## **OFFICIAL NOTIFICATION OF DECISION**

**Project# PR-2021-005628**  
**Application#**  
**SD-2023-00034 FINAL PLAT**

1. This request is for a subdivision of Tract 17 of the Artiste Subdivision into 13 new tracts (Tracts A through M of the City Center) comprising a total of 134.7249 acres.
2. The property is zoned PC (Planned Community). Future development must be consistent with the Mesa del Sol Master Plan/Framework Plan.
3. An Infrastructure List was approved by the DRB on May 18, 2022 per SD-2021-00214, and an approved and recorded Financial Guaranty/Infrastructure Improvements Agreement was submitted with the Final Plat application submittal.
4. The applicant provided the required notice as outlined in the IDO Table 6-1-1.
5. The Final Plat is consistent with the approved Preliminary Plat (SD-2021-00214).

TRACTS A THRU M  
CITY CENTER  
BEING A REPLAT OF TRACT 17 OF ARTISTE  
(BULK LAND PLAT, TRACTS 1 THROUGH 18, ARTISTE)  
CITY OF ALBUQUERQUE  
BERNALILLO COUNTY, NEW MEXICO  
FEBRUARY, 2022

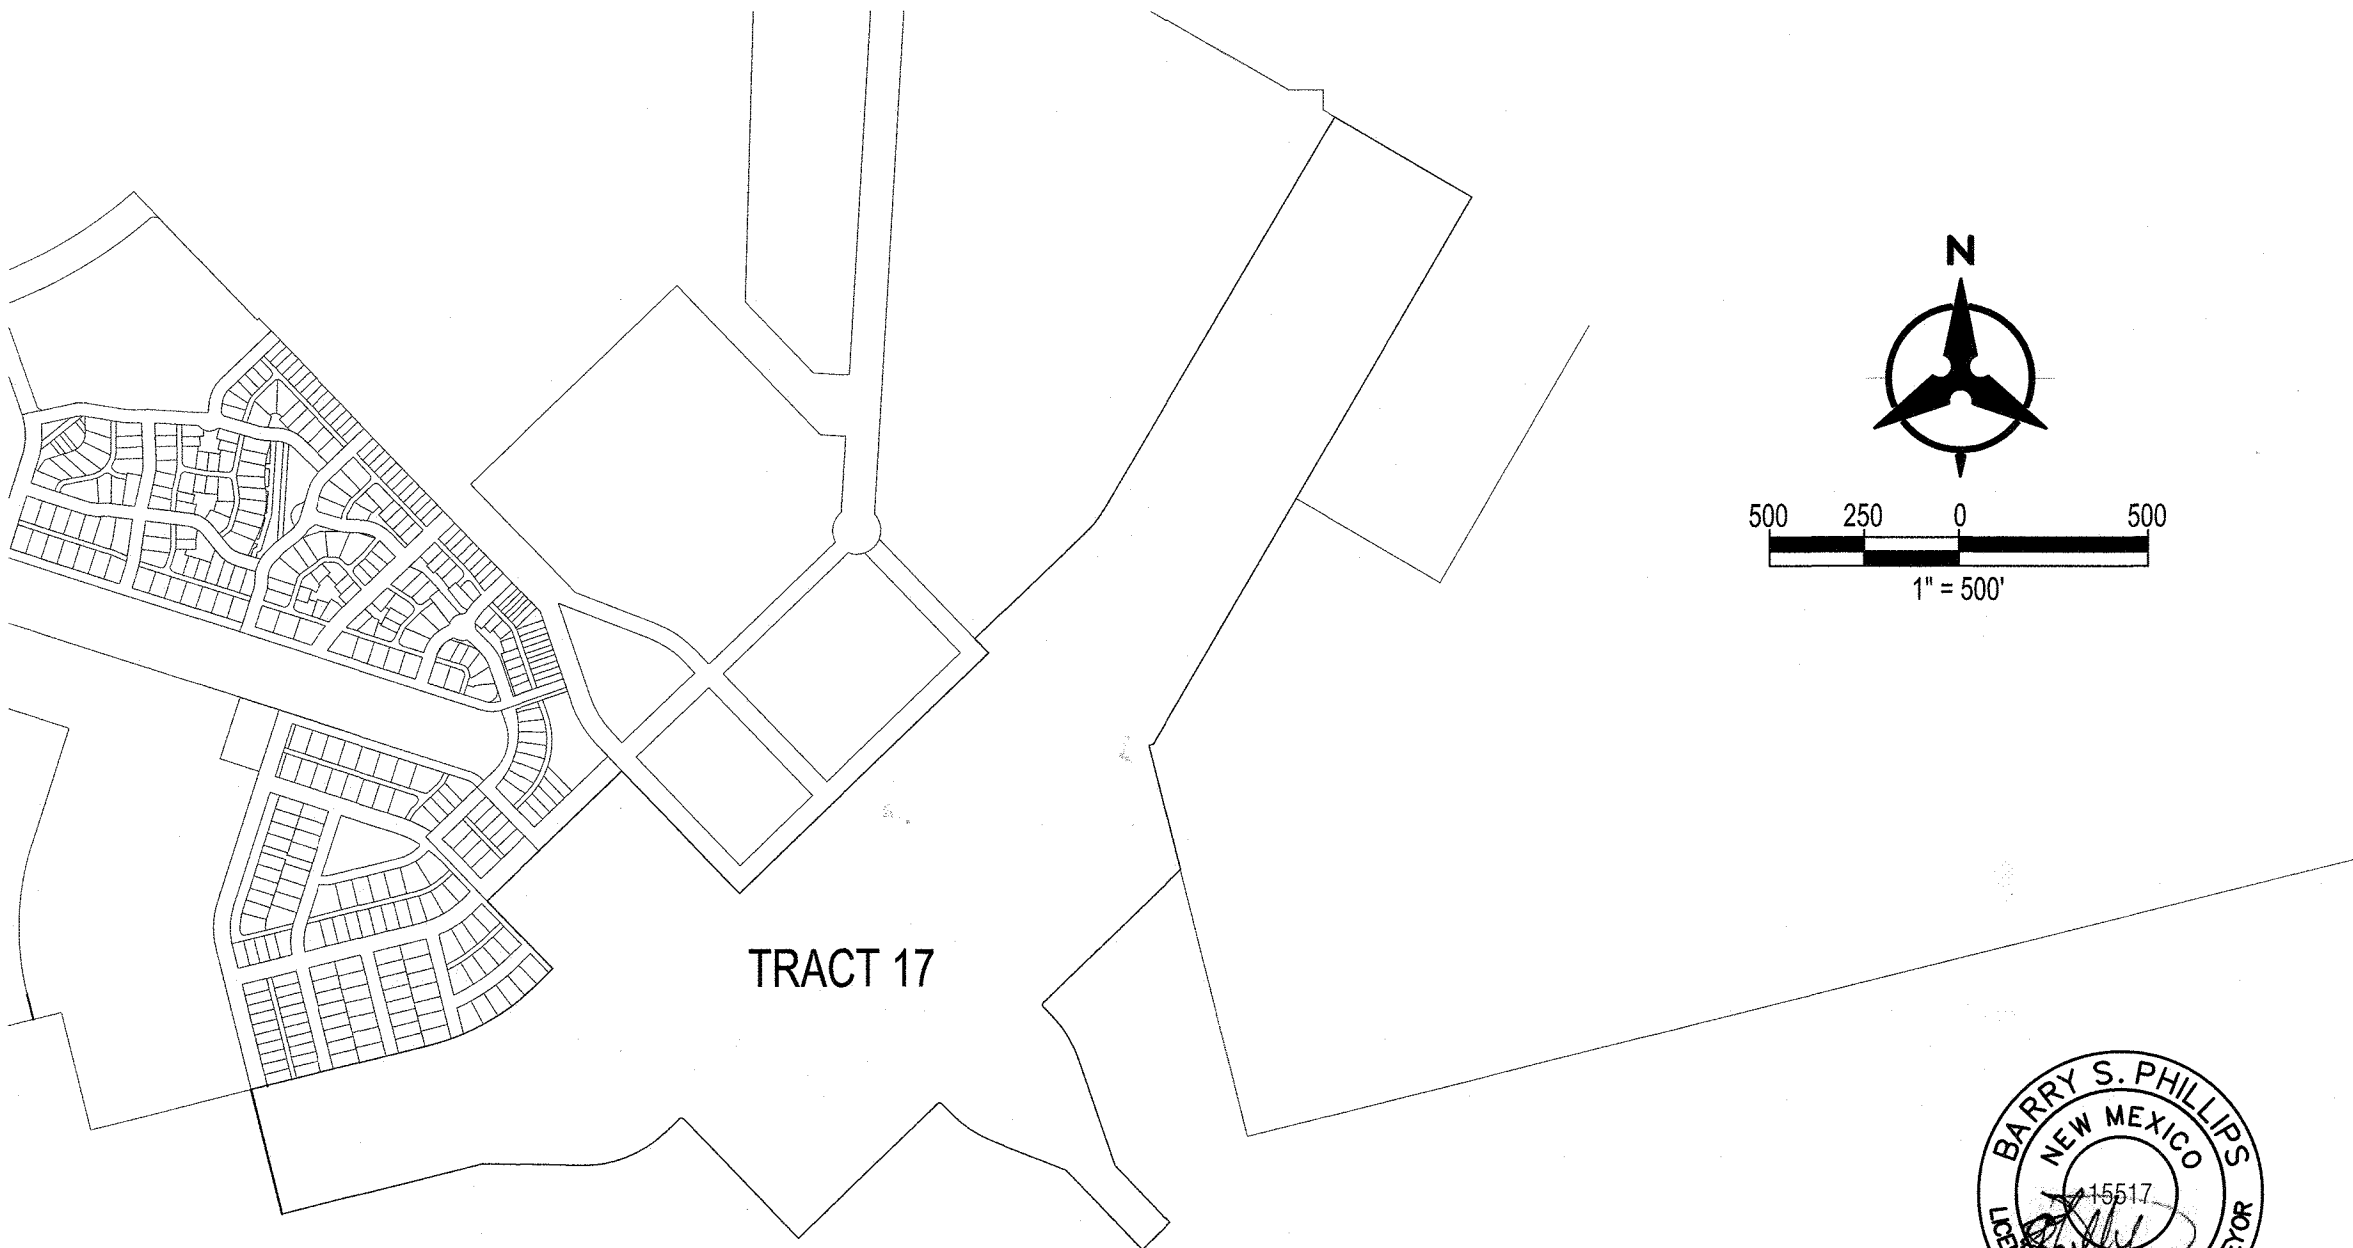
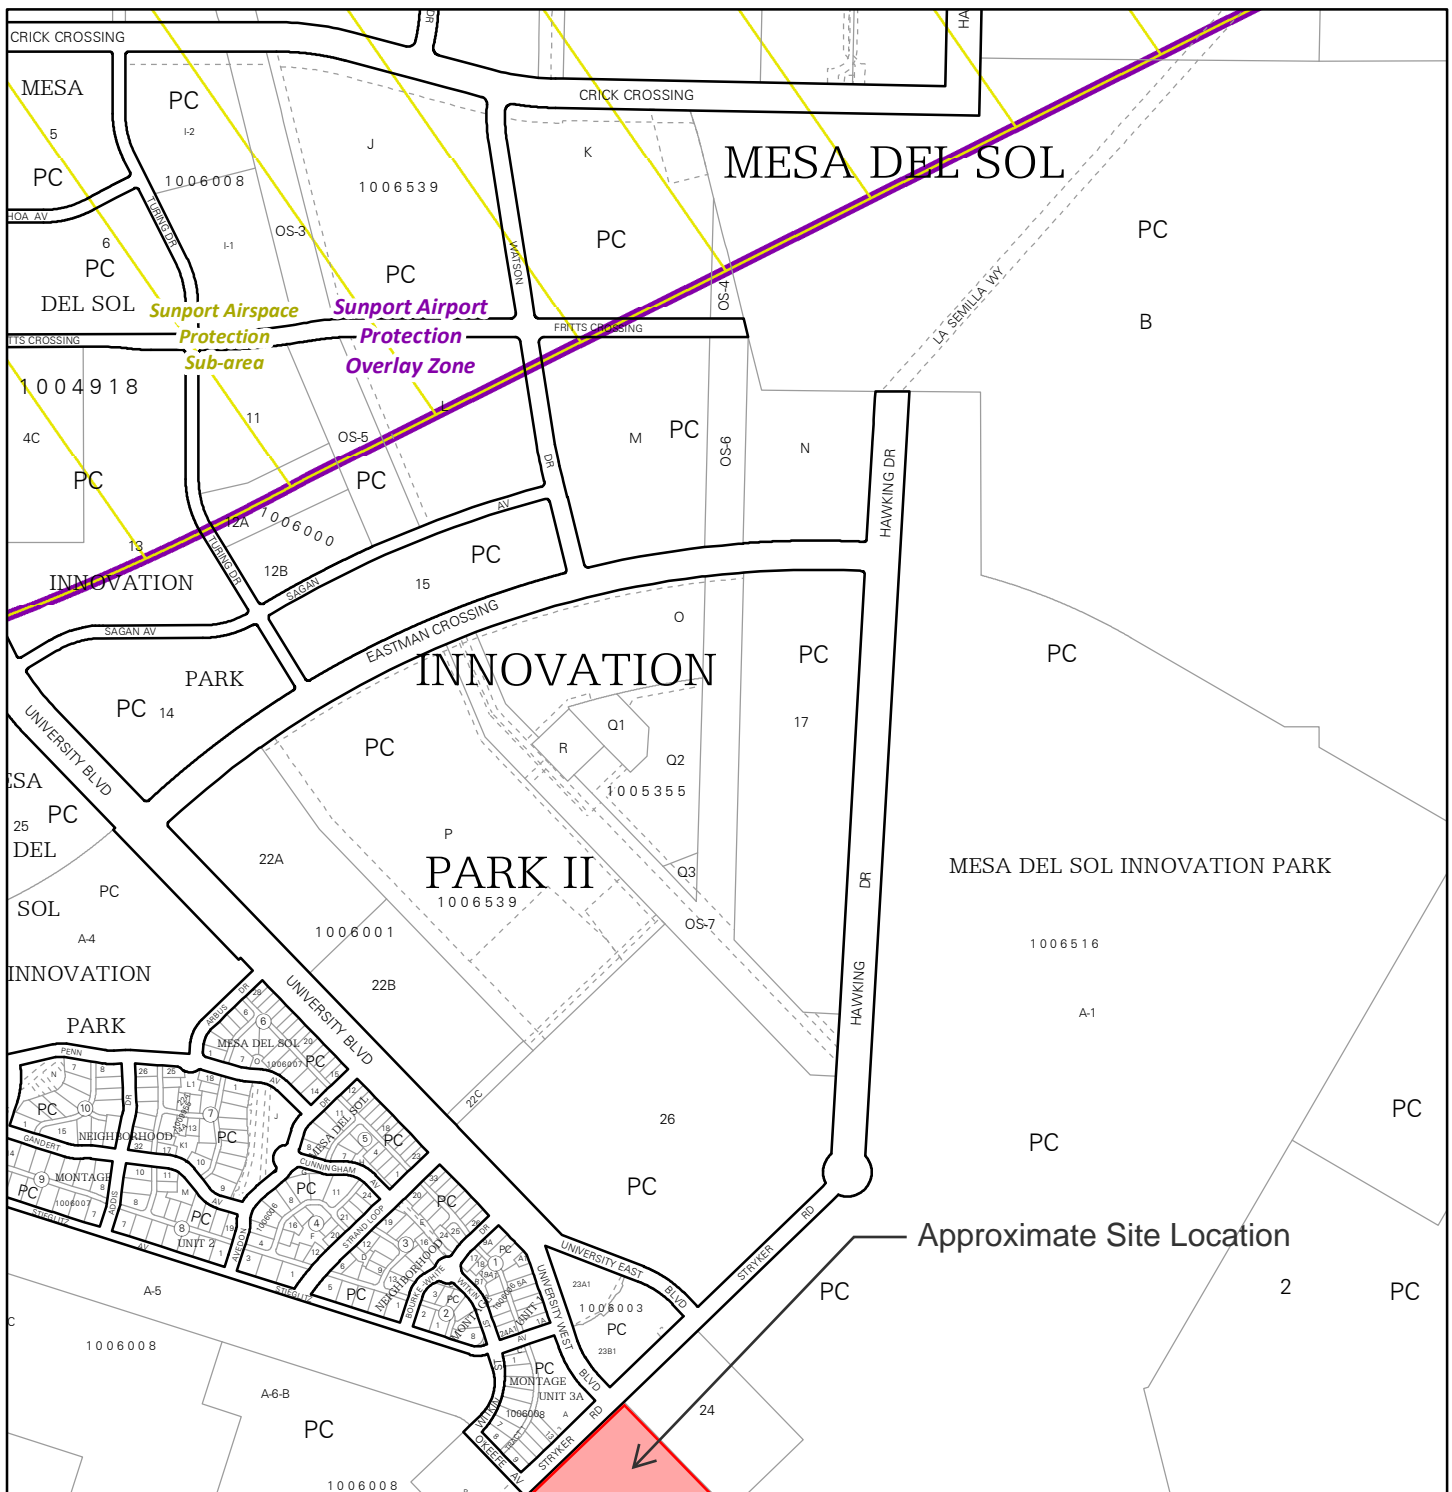
- a. Release of the ABCWUA paper easement as discussed at the February 8, 2022 DHO hearing.
- b. Correct the application number on the Plat, add a signature line for Hydrology to the Plat, and correct the Planning signature line on the Plat.
